Our Ref: PGH:12-0411  
Your REF: **SSI-5100**

**North West Rail Link (SSI-5100)**  
**Submission Kindalin Childcare Centre, No.1 Glenhope Road West Pennant Hills**

Further to our recent meeting on 19<sup>th</sup> April 2012 with Cecilia Densham and other representatives and following a review of the Environmental Impact Statement on exhibition (Environmental Impact Statement Stage 1-Major Civil Construction Works) we provide a number of comments for the Department's consideration.

Figure 7.1: Cherrybrook Station Heavy Vehicle Routes (Source: EIS, Volume 2)

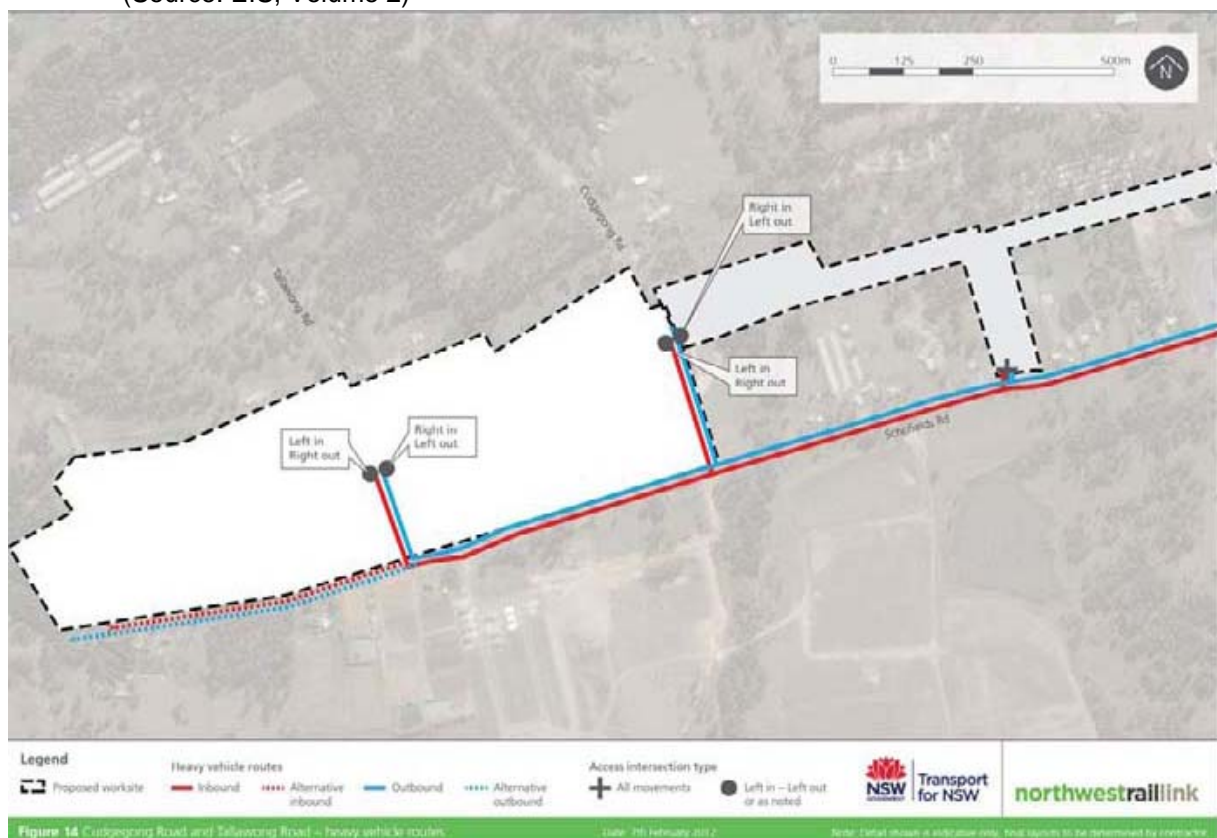
The noise and traffic impacts are associated with construction works at Cherrybrook Station. This construction involves spoil removal activities and associated truck movements over a 24 hour operation/7 days per week and construction of a new access point (traffic lights) immediately adjacent to Kindalin Childcare. The majority of truck movements are anticipated between the hours of 7am to 6pm and involve truck-and-dog or semi-trailer tippers able to carry 12.5m<sup>3</sup>. The technical paper (*Construction Traffic and Transport Management, Tables 2.4 & 2.5*) estimates overall tunnelling heavy vehicle movements for Cherrybrook Station at 29,600 trucks or 275 per day (one way).

This is a significant increase in daily truck movements in the immediate vicinity of the site. The concerns of the childcare centre relate to the potential impacts associated with noise and traffic impacts for the construction of Cherrybrook Station, specifically:

- Frequency and noise of associated truck movements associated with daytime operations (7am – 6pm) including impacts on both indoor and outdoor activities.
- Impacts of traffic on the functioning of the car park area during peak traffic times for the centre (drop off and pick up) during the hours 7.30am. -10.00am and between 4.00pm and 6.00pm.
- Sleep disturbance for children during daytime rest period (1.00pm to 3.00pm).

- Construction of a heightened perimeter wall along the Castle Hill Road and Glenhope Road frontage of the site to provide an appropriate acoustic barrier between the site and predicted noise sources. The final height would need to be clarified by the Acoustic Engineer; however it is understood from the submitted Noise and Vibration Report that noise impacts can be reduced through provision of acoustic barriers.
